**KIRKLEES METROPOLITAN COUNCIL
INVESTMENT & REGENERATION SERVICE**

DELEGATED DECISION TO DETERMINE PLANNING APPLICATIONS

Reference No: 2018/62/93103/W

Description: Erection of front porch and rear dormer window and
increase gable window

Drawing Number: **18/A/40** **SK-01** **C**

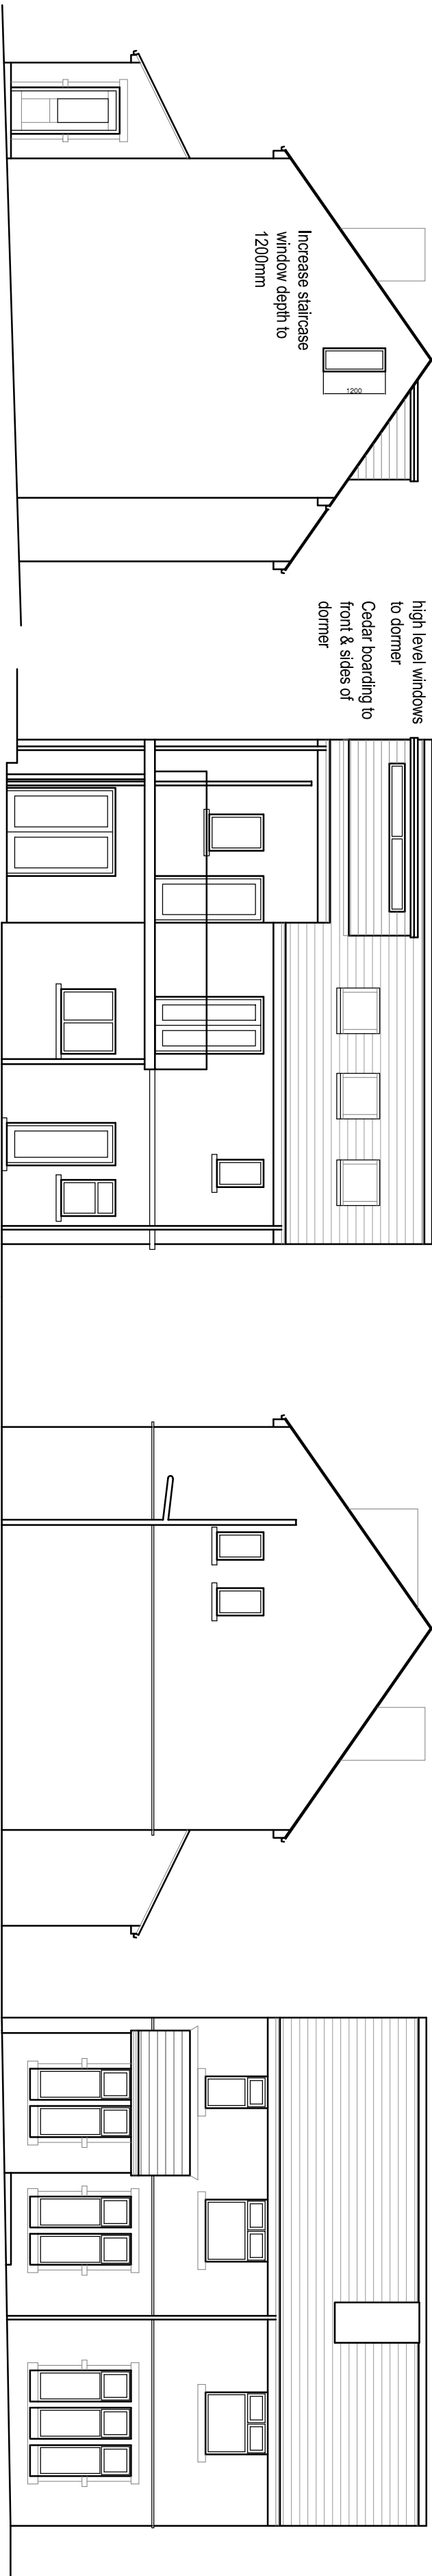
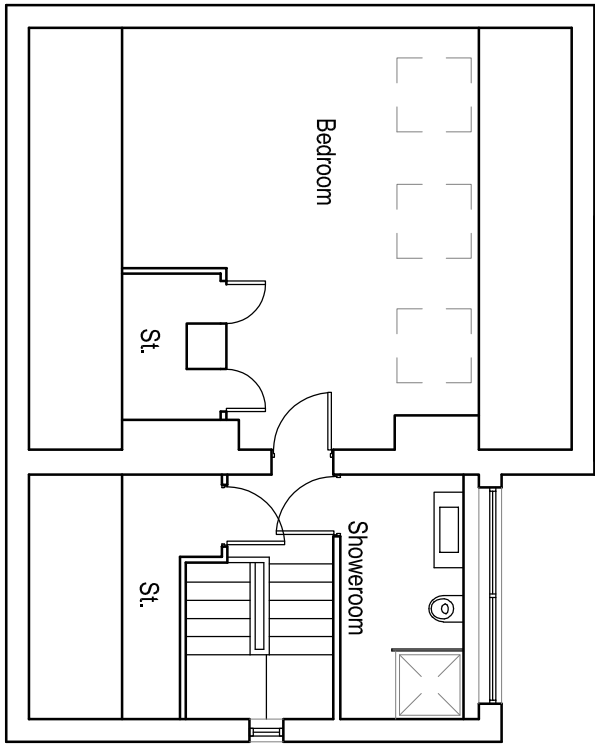
subject to the roof of the porch being roofed with blue slate (to match the main roof) rather than single ply referenced on the application form (As discussed with the agent) and would thereby comply with the aims of Policies D2, BE1, BE2, BE14 and BE13 of the UDP and Policy PLP24 of the PDLP.

3. The roof covering of the porch hereby approved shall be blue slate to harmonise with the roof of the host dwelling.
